From: Chantelle Bashford <Chantelle.Bashford@arun.gov.uk>
Sent: 13 August 2021 12:08
To: Planning.Responses <Planning.Responses@arun.gov.uk>
Subject: RE: Planning Consultation on: LU/212/21/PL

Please see Private Sector Housing comments, below. These comments are in relation to general housing conditions and have regard to the Housing Act 2004, Housing Health and Safety Rating System (England) Regulations 2005 and LACoRS national fire safety guidance.

Application No: LU/212/21/PL
Registered: 15th July 2021
Site Address: 3-4 Selborne Place Selborne Road Littlehampton BN17 5NH
Grid Reference: 503313 101643
Description of Works: Change of use from A3 Restaurant / A4 Drinking Establishment to C3 Dwelling Houses (5 No. 1-bed flats & 1 No. 2-bed flat). This application may affect the setting of a listed building, may affect the character & appearance of the Littlehampton Sea Front Conservation Area & is in CIL Zone 4 (Zero Rated) as flats.

Proposed Ground Floor Layout Plan

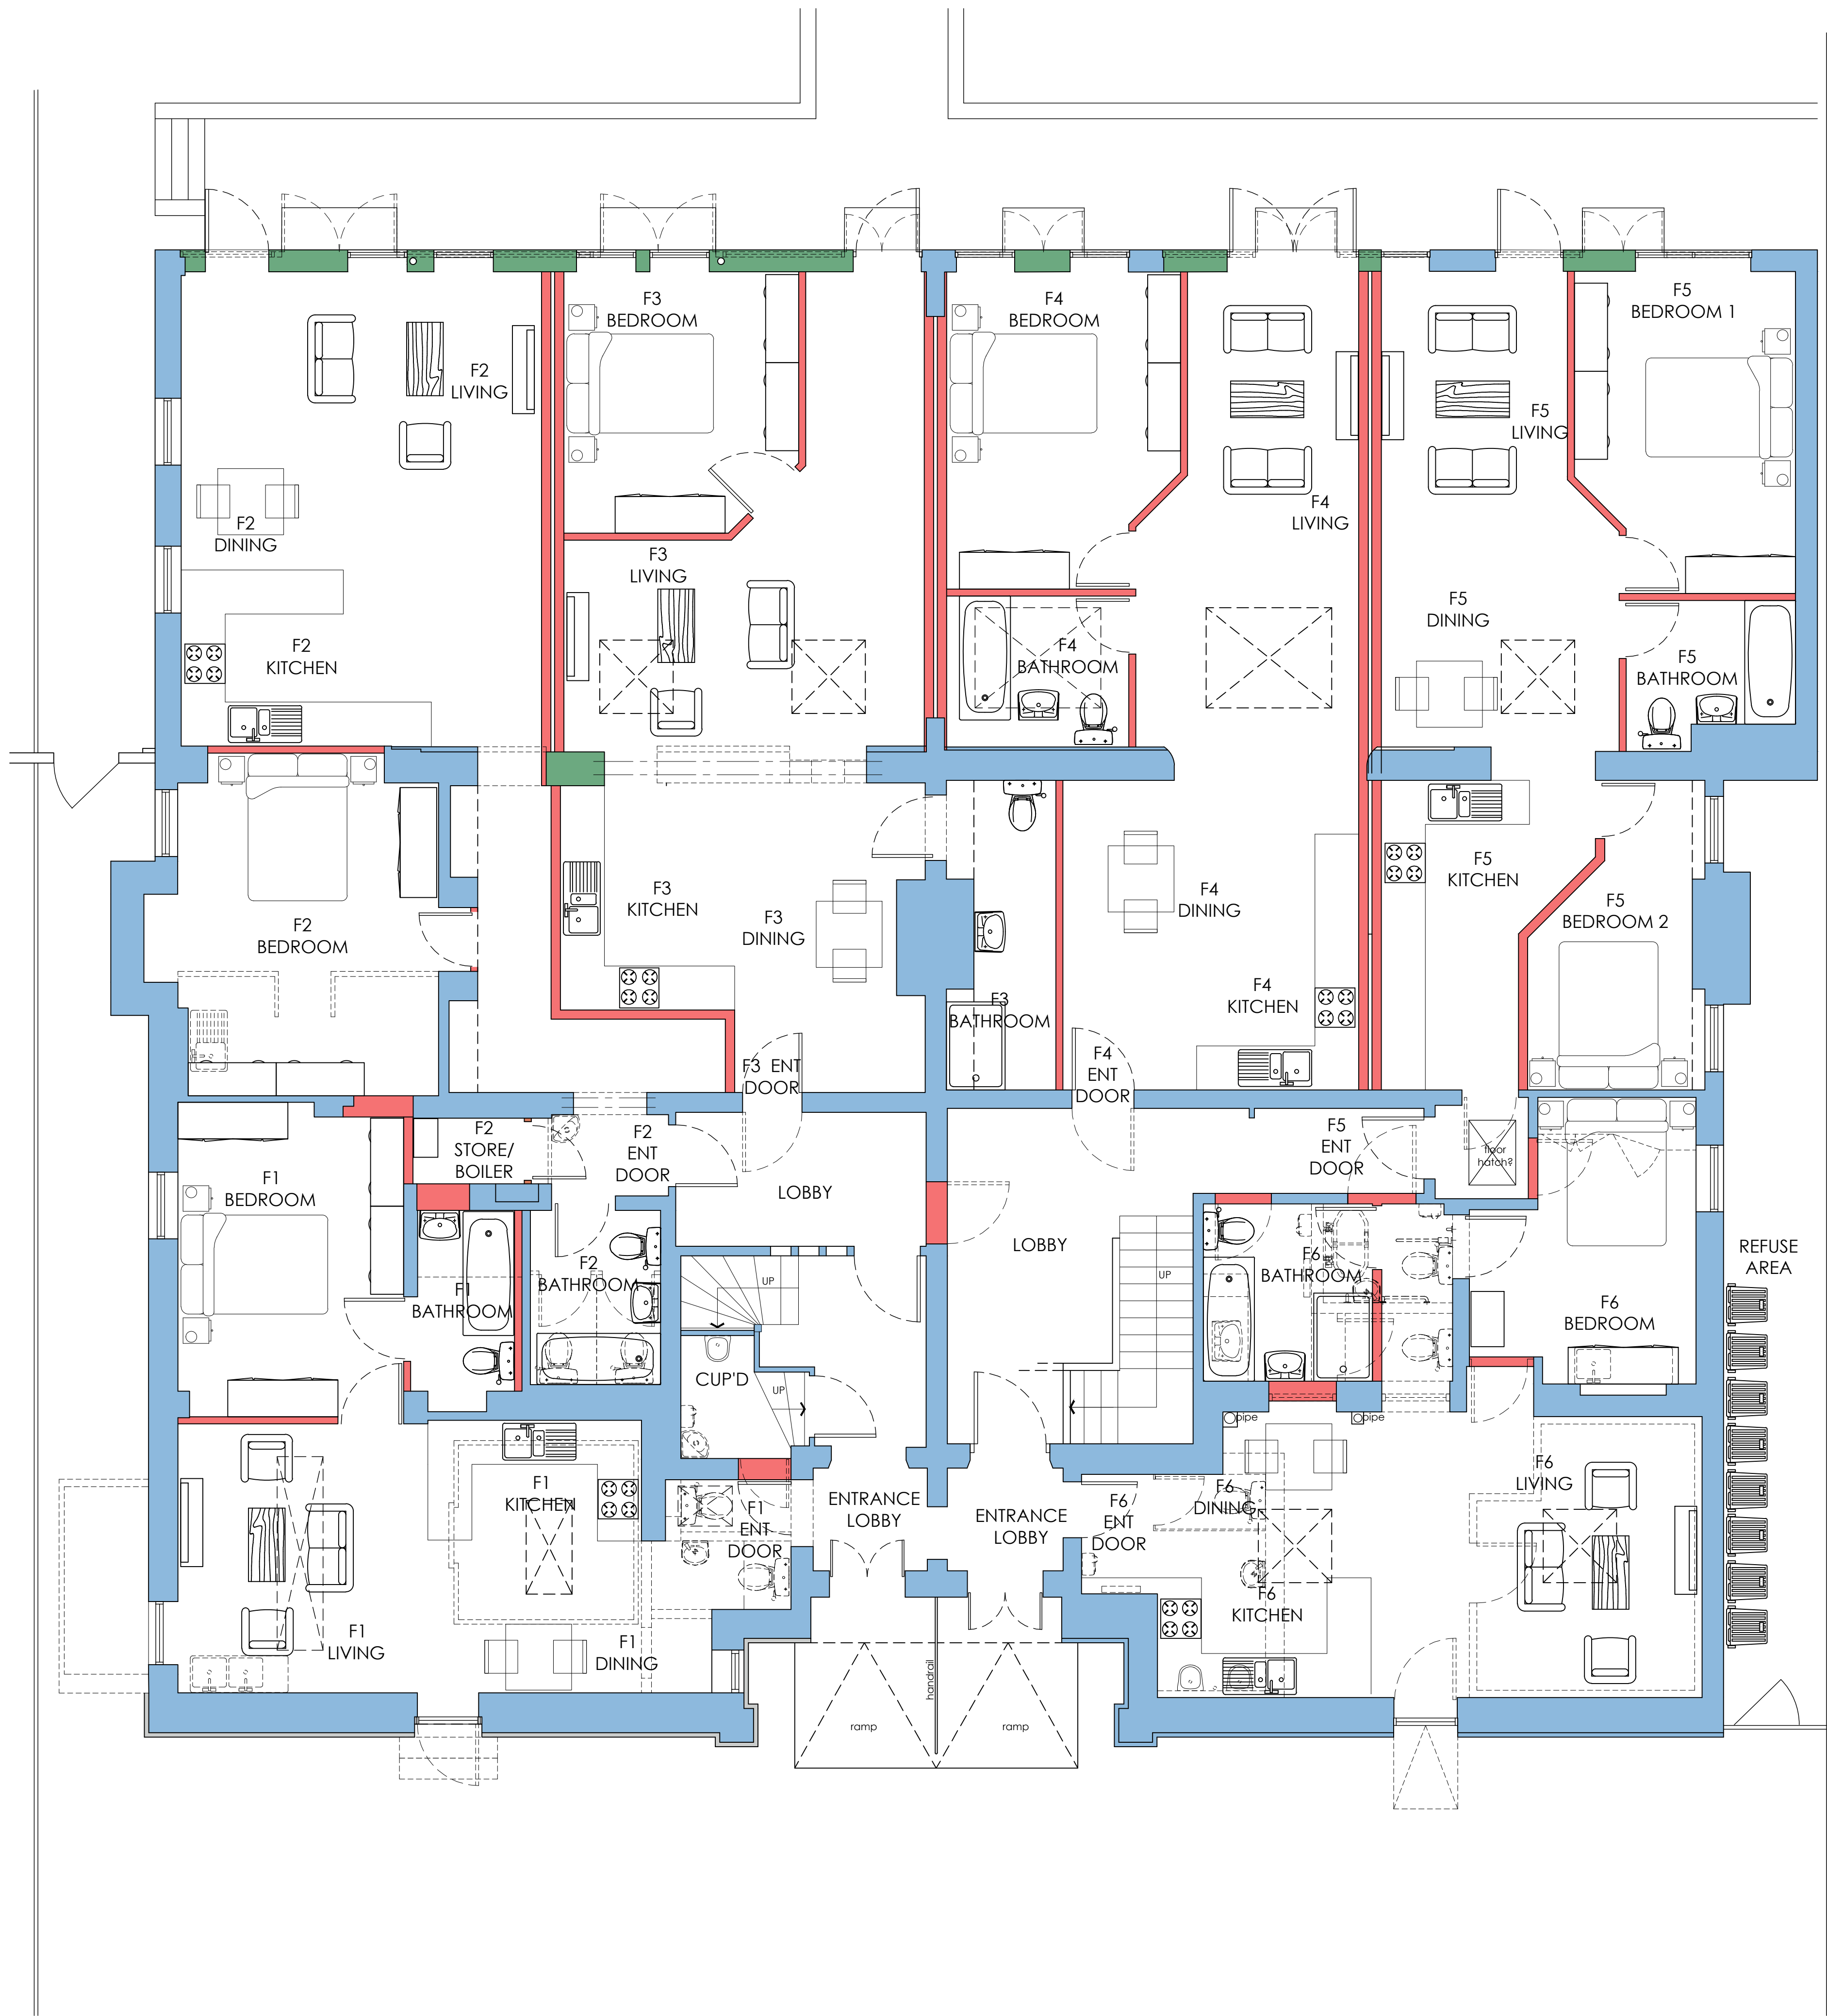
Flats 1 & 6

- Escape window to be fitted to the bedroom

- Additional Grade D1 interlinked smoke detector to the bedroom
- Fire door (FD30S) to be fitted to the bedroom

Flat 5

- Escape window to be fitted to bedroom 2
- Additional Grade D1 interlinked smoke detector to bedroom 2
- Fire door (FD30S) to be fitted to bedroom 2

Flat 5 bedroom 2 appears particularly small, ensure it meets the minimum sizes as above
